**Wellington Solar Farm Modification 2 (SSD 8573 Mod 2)
Response to Request for Information**

In response to the Department of Planning, Industry and Environment's requests for additional information in relation to the Wellington Solar Farm Modification 2 (SSD 8573 Mod 2) dated the 6th and 13th of March 2020, please find below responses to the clarifications requested, as well as attached:

Figure 3-3 PCTs and TECs at the development site

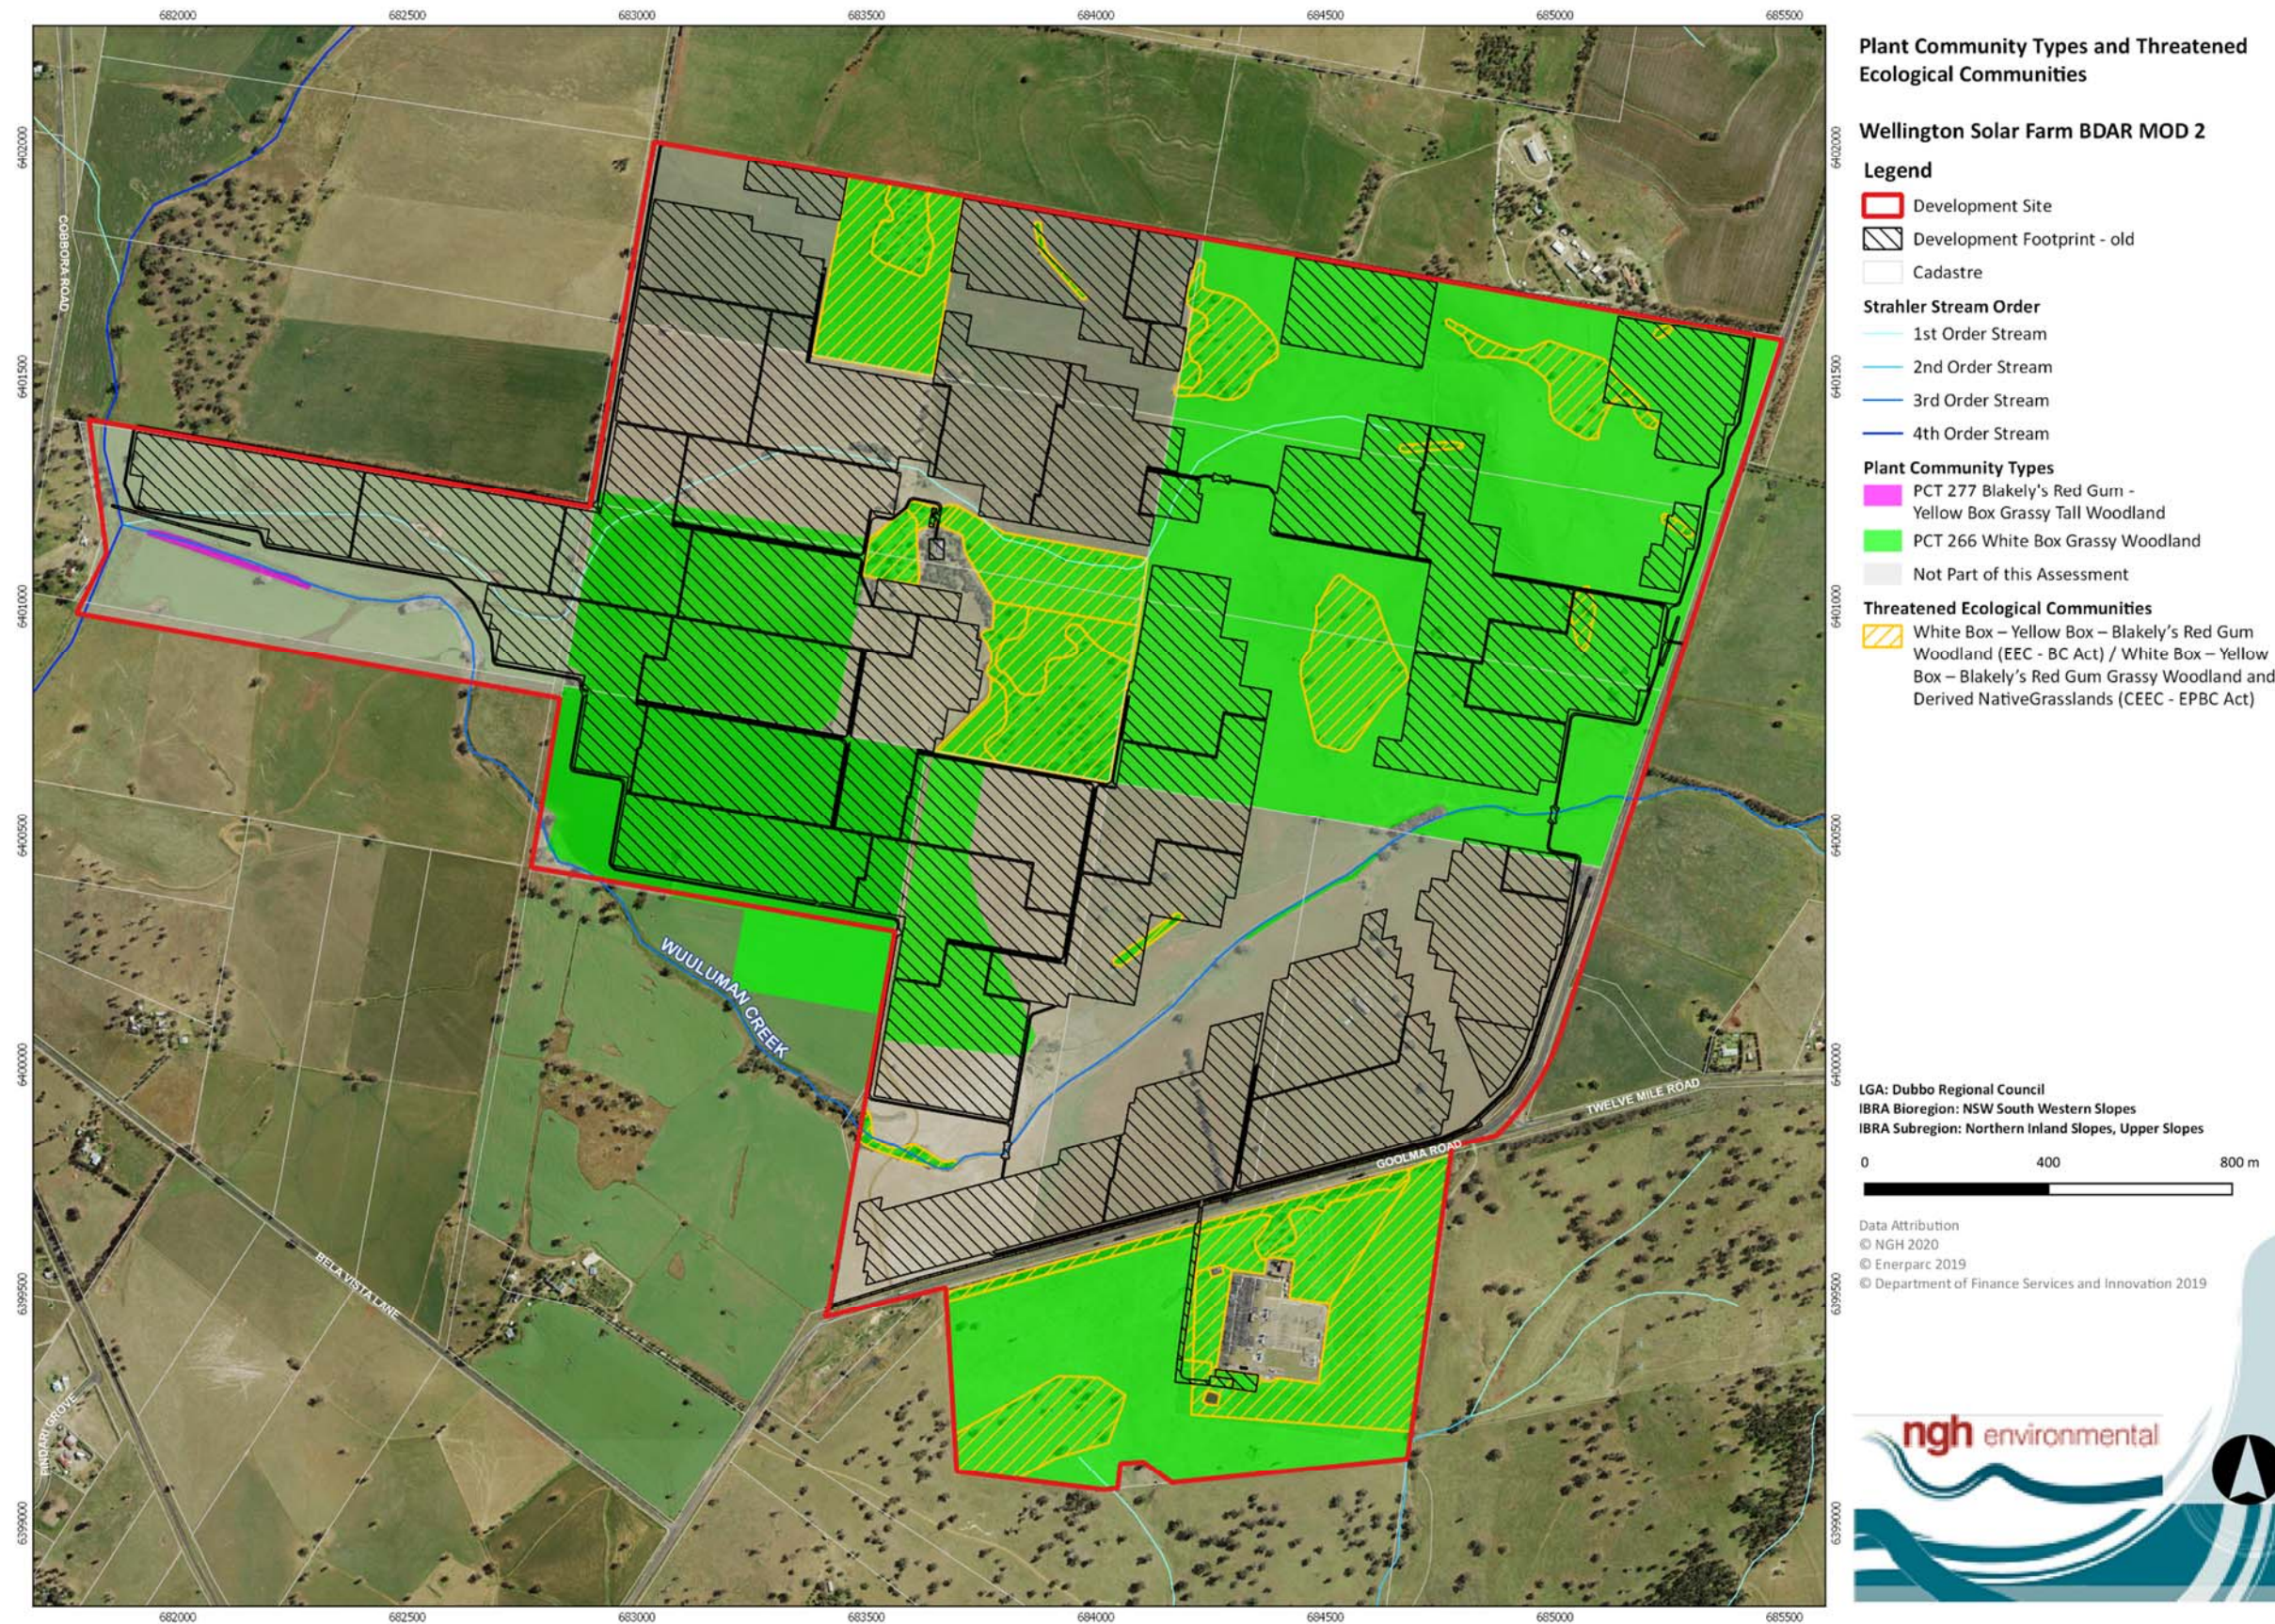
1.2 An additional SAIL assessment for White Box – Yellow Box – Blakely’s Red Gum EEC should be conducted in accordance with section 10.2.2 of the BAM.

Areas that comprise White Box Yellow Box Blakely’s Red Gum Woodland EEC, have been excluded from the development footprint as much as possible. Specifically, all White Box Yellow Box Blakely’s Red Gum Woodland listed as Critically Endangered Ecological Community (CEEC) under the EPBC Act, has been excluded from the development footprint. However, there is a small area of White Box Yellow Box Blakely’s Red Gum Woodland EEC listed under the BC Act present within the benching and cabling for the substation. See Figure 3-3 of the revised BDAR.

The impacted area around the substation comprises:

- 0.39 ha of BC Act listed EEC that was assessed under the SSD/MOD 1 approvals and is considered an impact consistent with the existing approval.
- 0.03 ha of BC Act listed EEC that is additional to that assessed under the SSD/MOD 1 approvals.
- 0.29 ha of BC Act listed EEC that is to be excised from that assessed under SSD/MOD 1 approvals and will no longer be impacted.

In summary the impacts to EEC of the proposed development (MOD 2) are less than that originally approved under SSD/MOD1 approvals as a larger area would be excised than would be added in this MOD 2 layout.
